January 16, 2025

Mavis Tires & Brakes
1585 Buffalo Lake Rd
Sanford, NC 27332

Project Number: 11432-187

This letter is in response to the plan review comments for the above-mentioned project. Corrections have been made and plans have been revised accordingly.

A-603

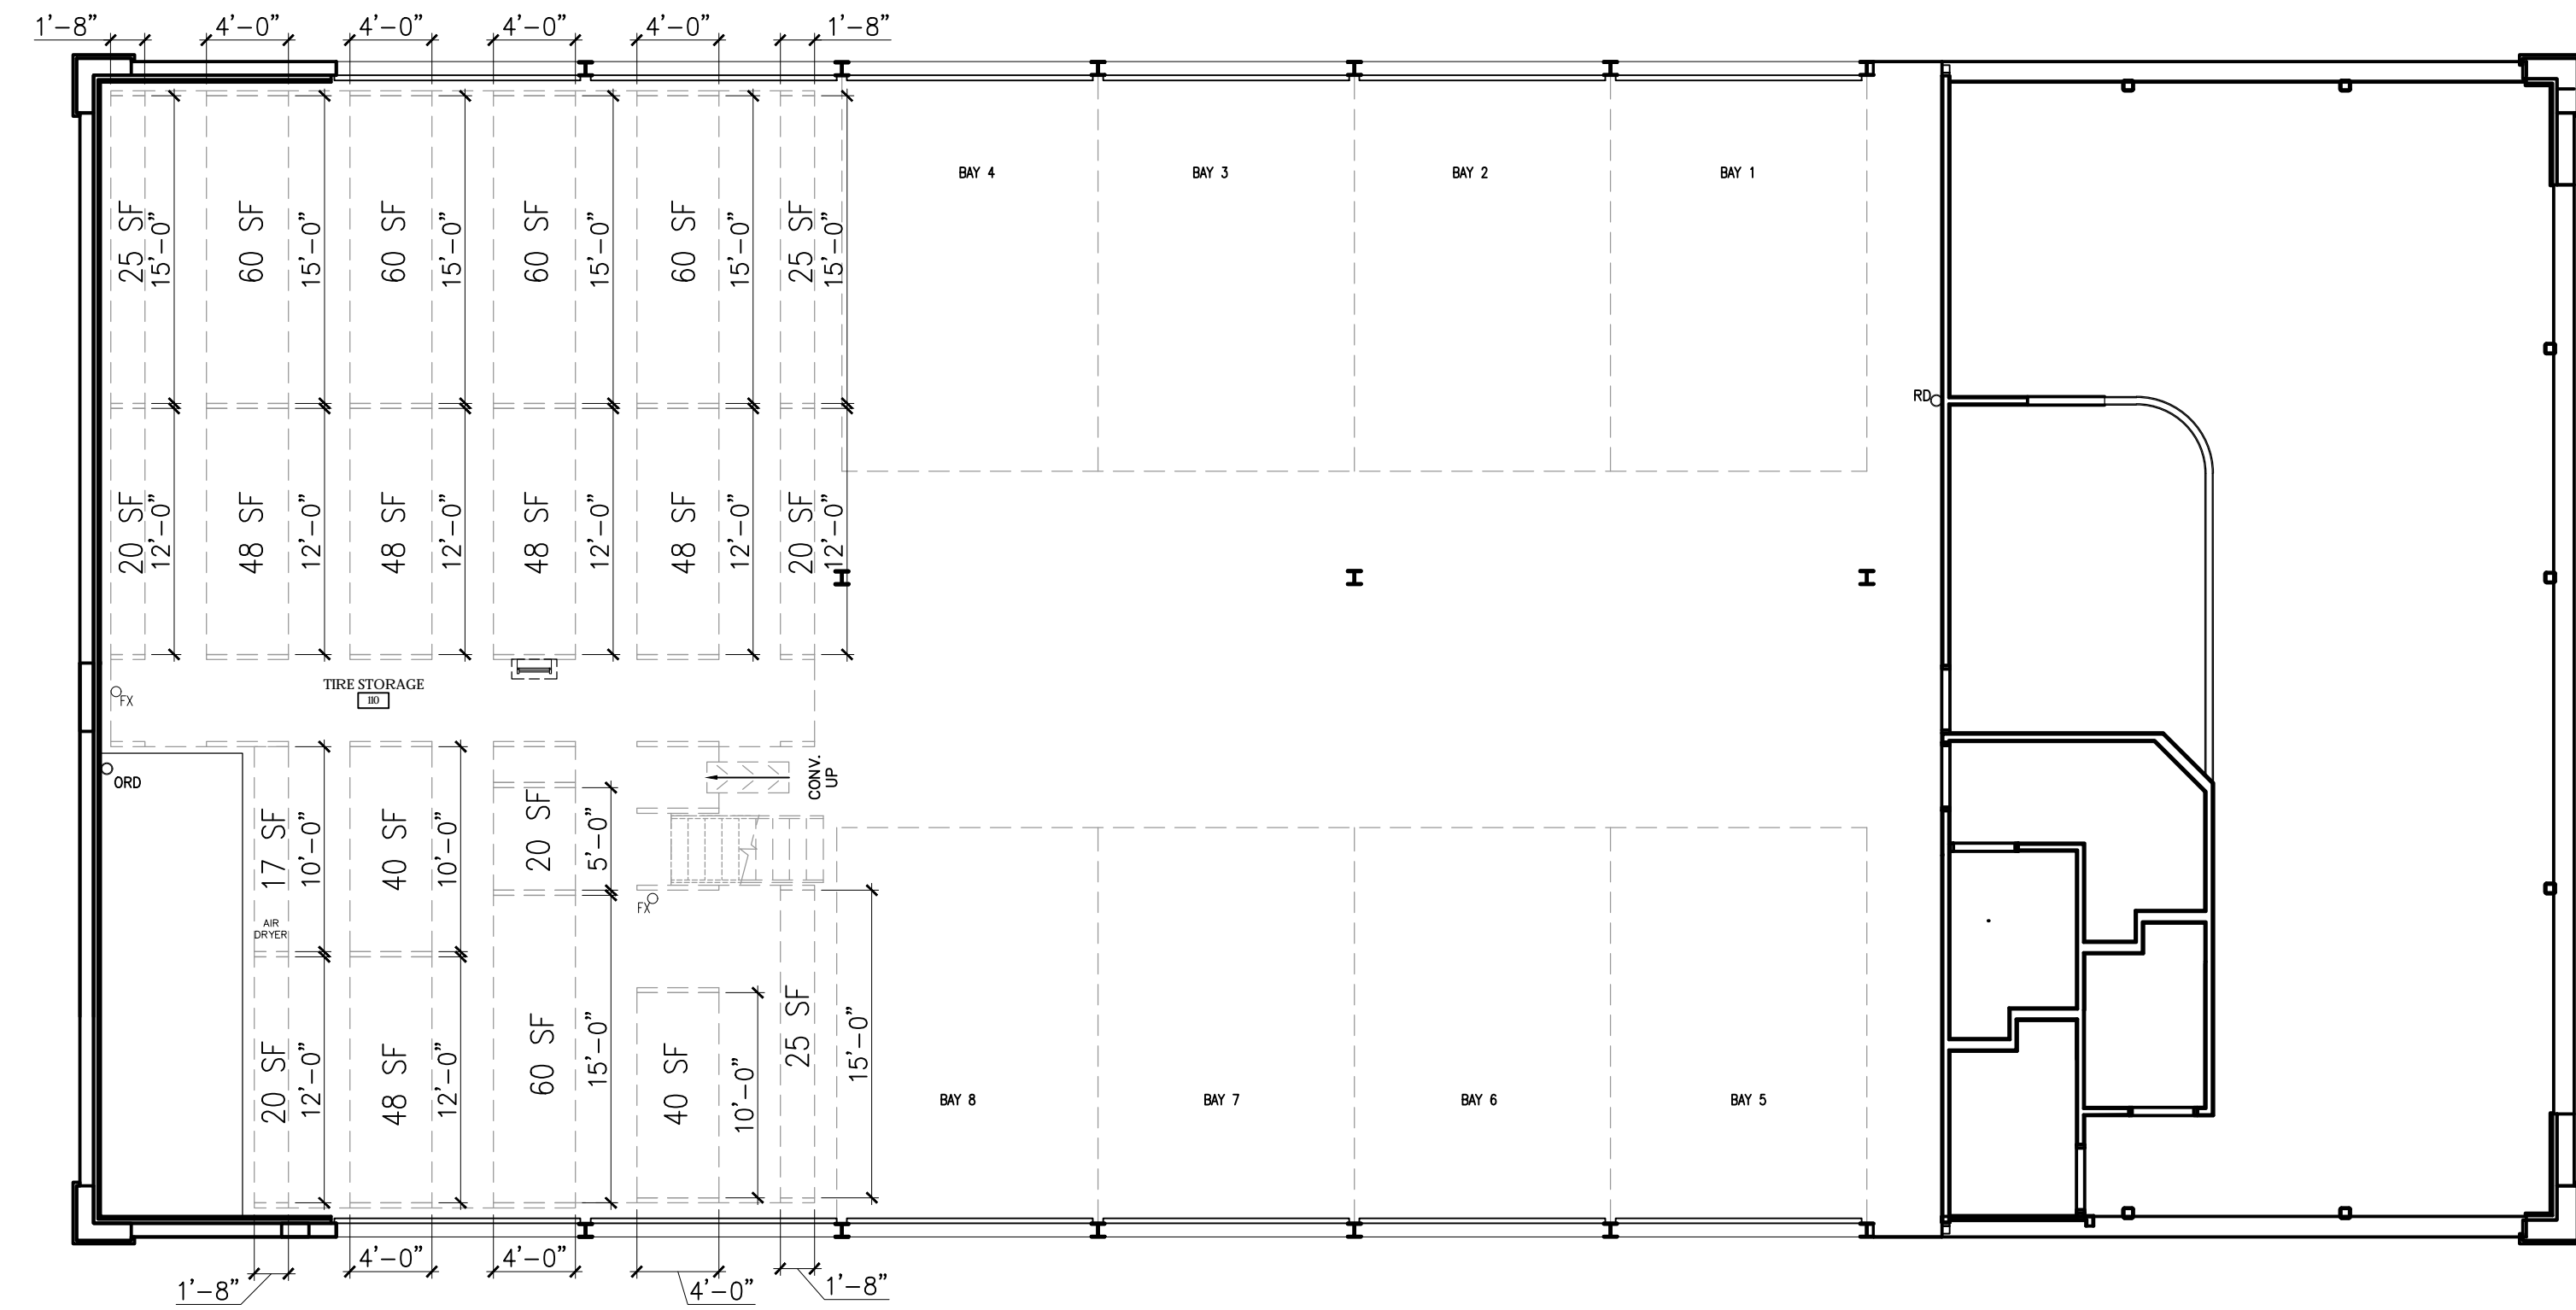
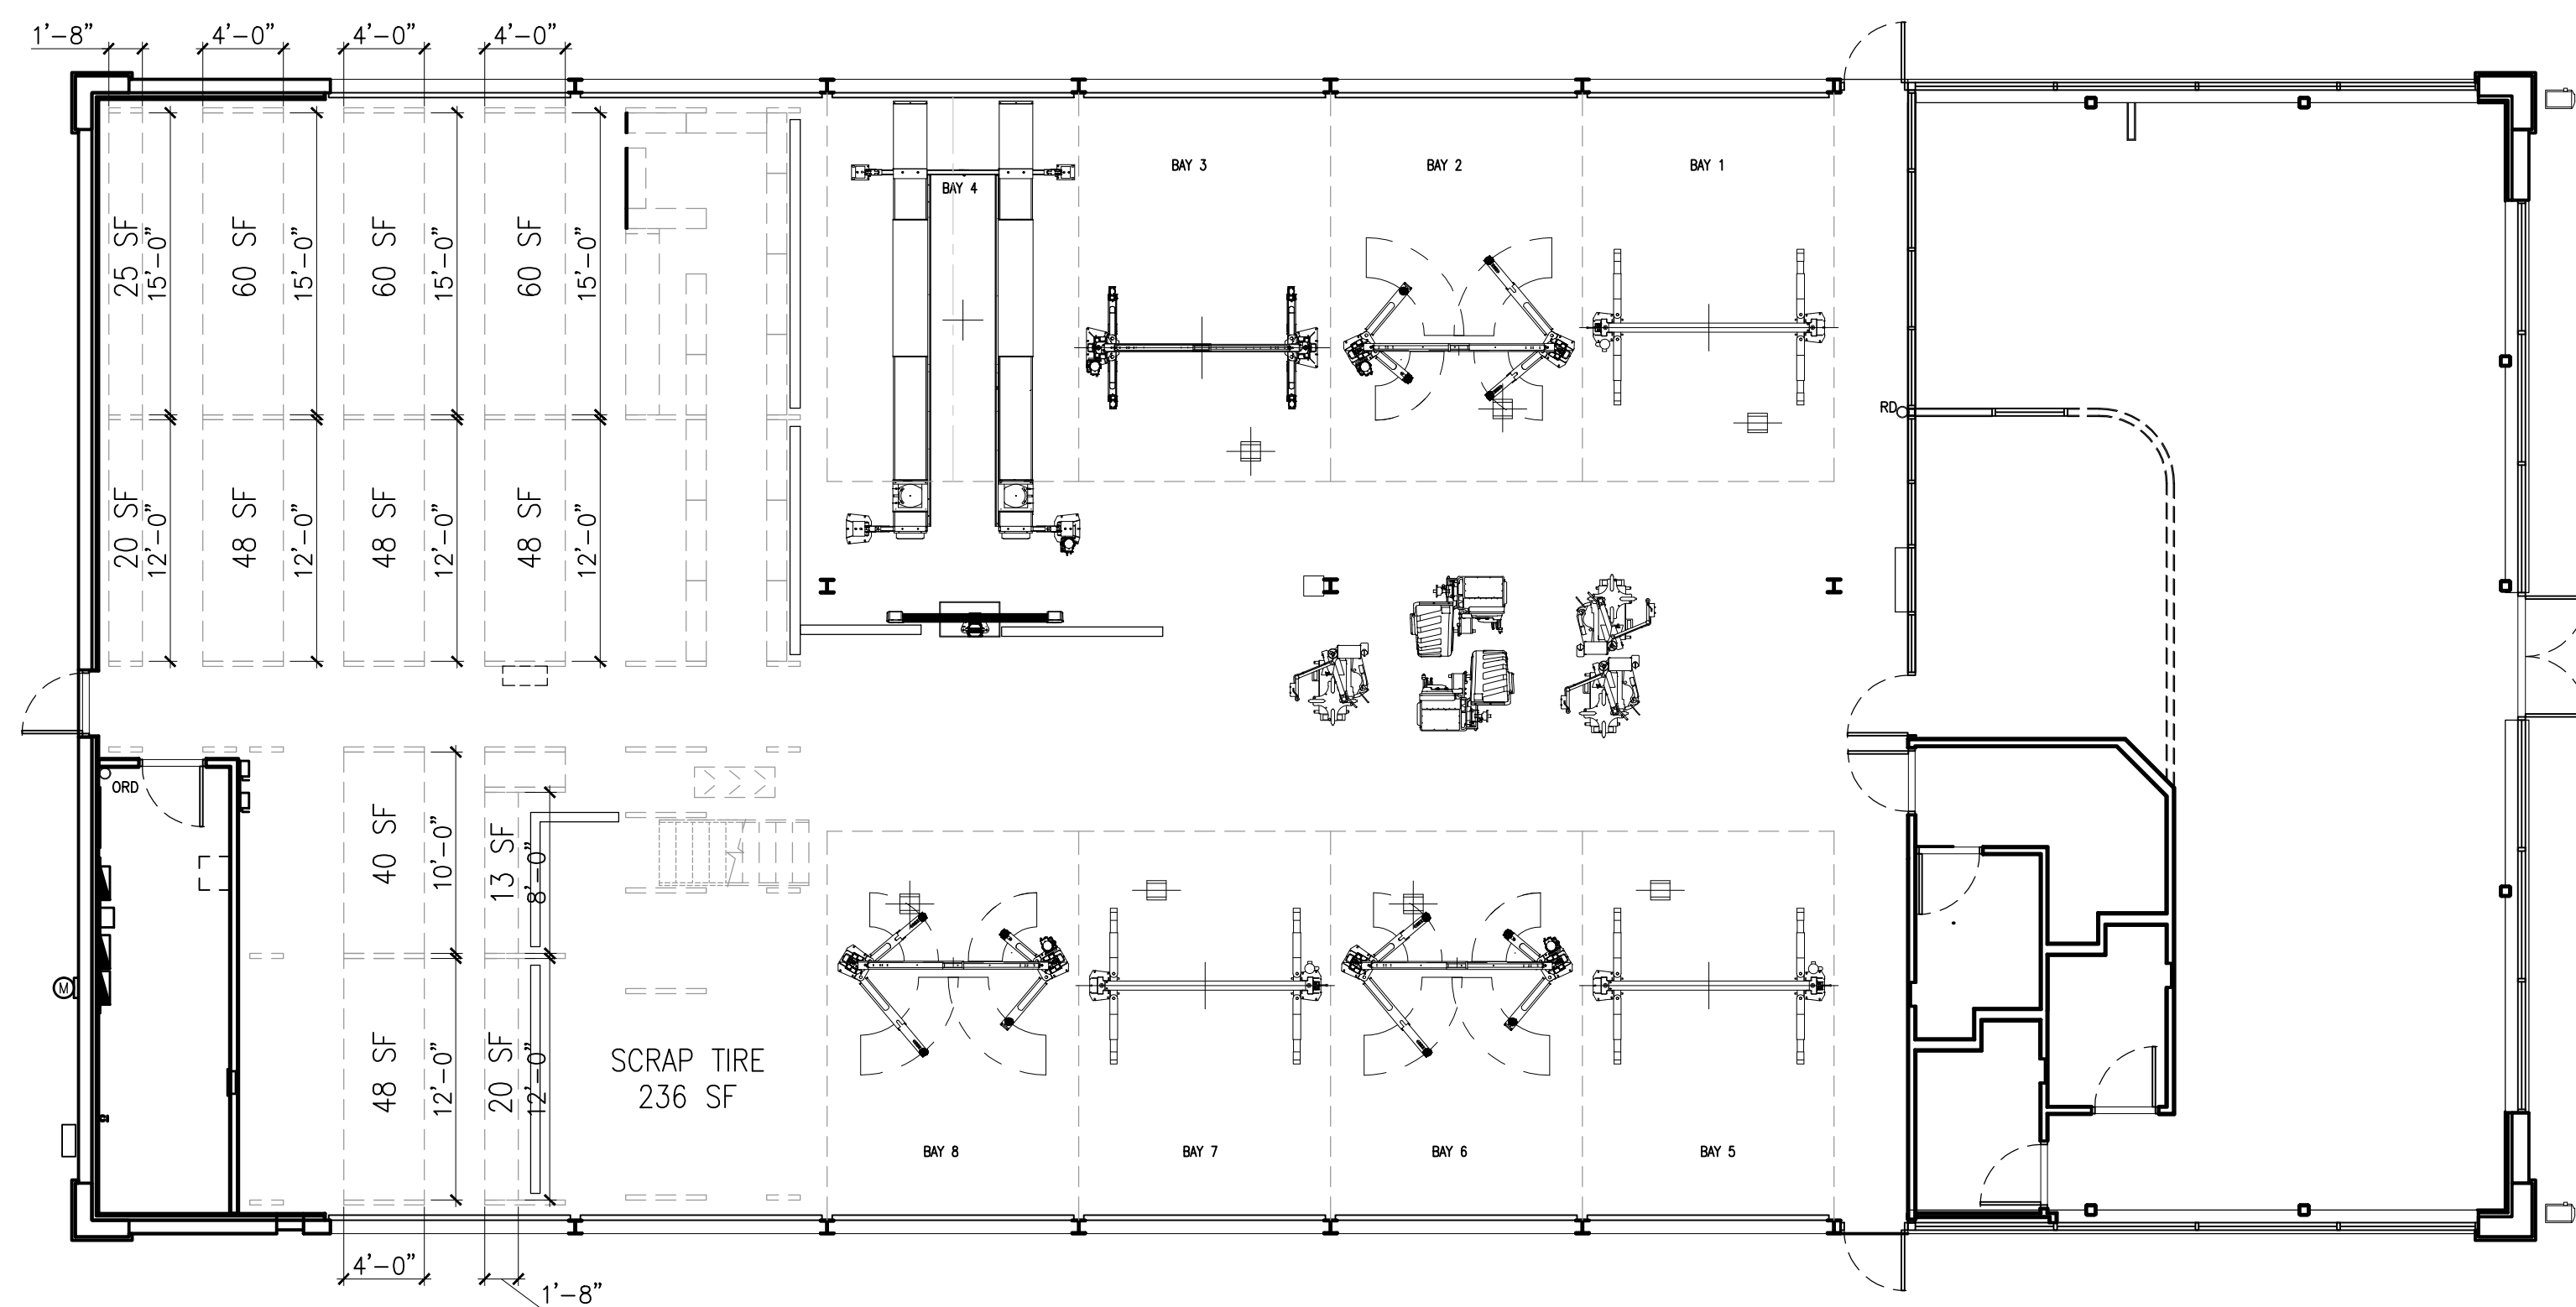
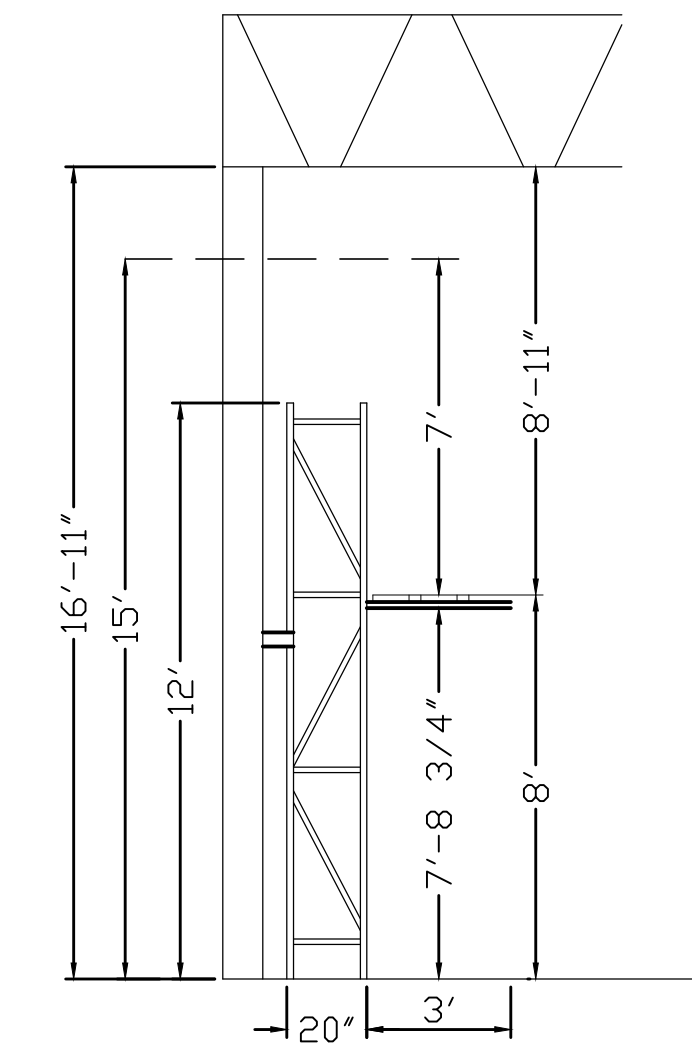
Comment #1 Need a specific detail and area calculation for tire storage area in cubic feet. If it exceeds 20,000 cubic feet, sprinklers will be required throughout the building. 2018 NCBC 903.2.9.2

Response: **Sheet A-603 has been added to set including tire storage calculations. Total tire storage volume has been calculated at 11,110 cubic feet and does not exceed the 20,000 cubic feet threshold requiring sprinklers in this area.**
